CITY OF ALBUQUERQUE

**Re: Nuevo Atrisco
Erosion and Sediment Control Plan
Engineer's Stamp Date 11-28-18 (K10E058)**

Based upon the information provided in your submittal received 12-20-18, the above referenced plan is not approved to be included in the SWPPP or for NOI documentation review for grading and Building Permit until the following comments are addressed:

STORMWATER POLLUTION PREVENTION PLAN

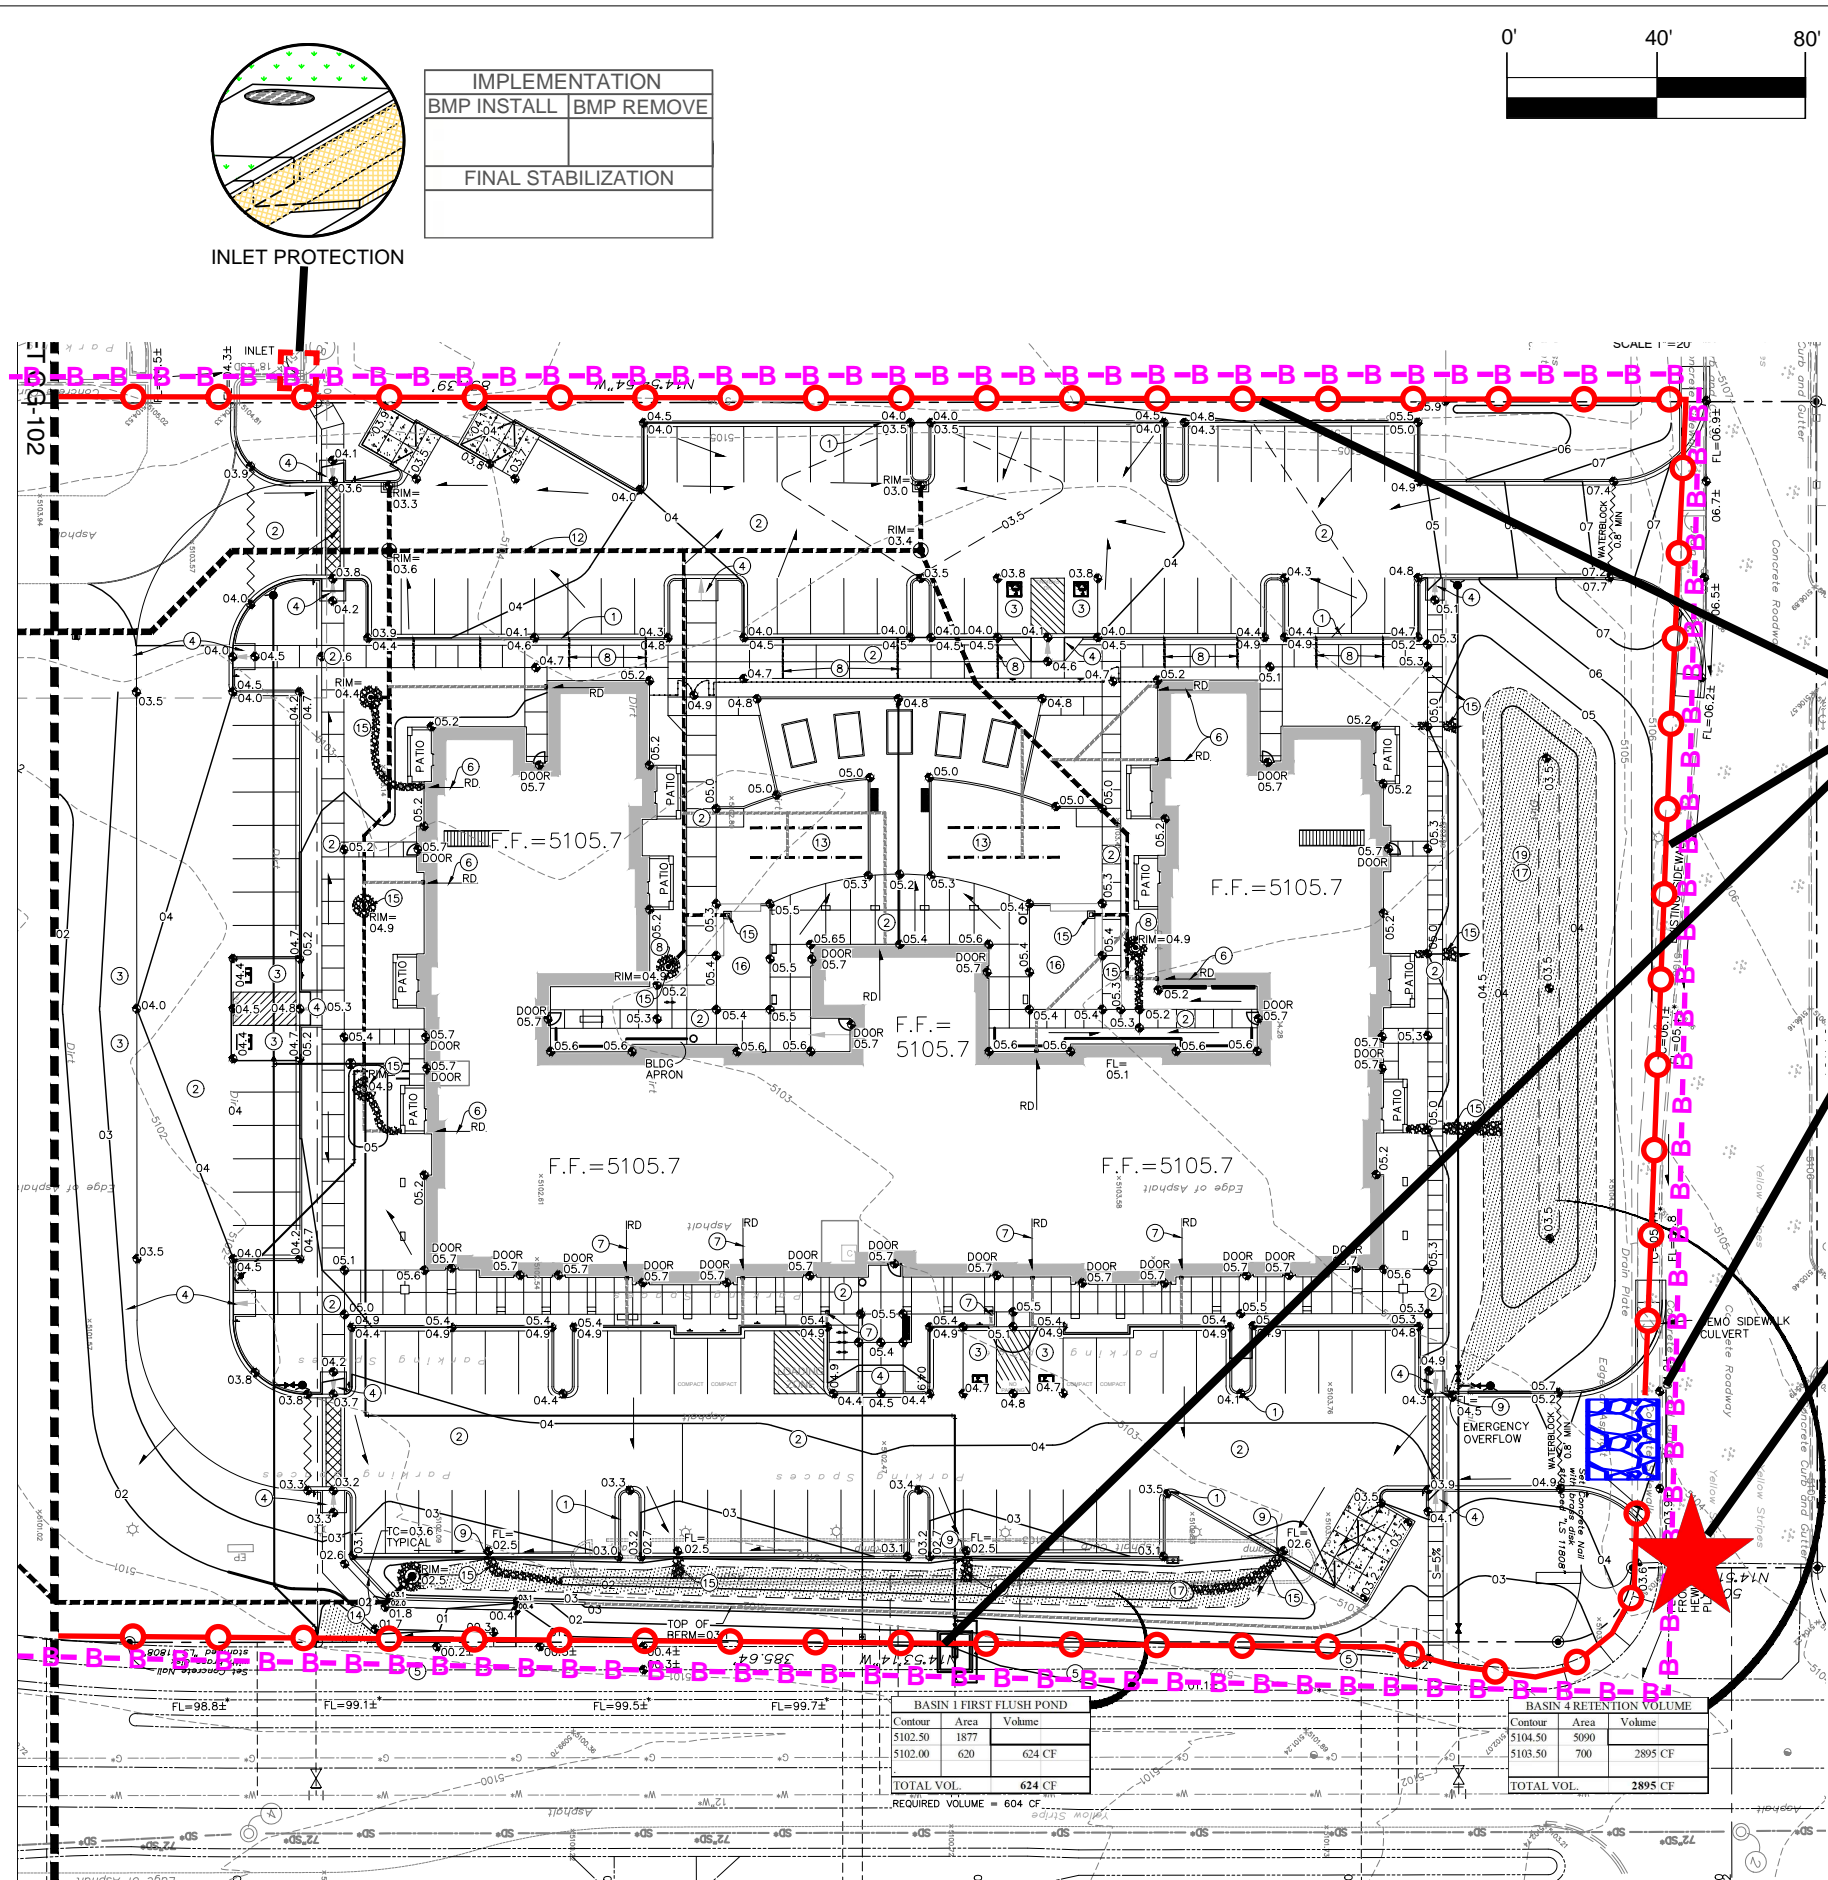
1. Provide a sediment BMP downhill from the building area to prevent sediment from entering Unser Blvd and Central Blvd.
2. Provide a sediment BMP downhill from the disturbed area where the storm drain is proposed south of the building area to prevent sediment from entering Unser Blvd and Central Blvd.
3. In the silt fence detail, provide a maximum pole spacing. In general maximum pole spacing is 10', but may need to be closer at corners or where higher flows are anticipated.
4. In the silt fence detail, specify the type of pole to be used. Poles to be 2"x2" wood or steel "U" or "T" type/.
5. Note 2 states "Parking and staging areas are located off site if not indicated on the drawing set." Please add that a sediment BMP(s) is required for these areas.
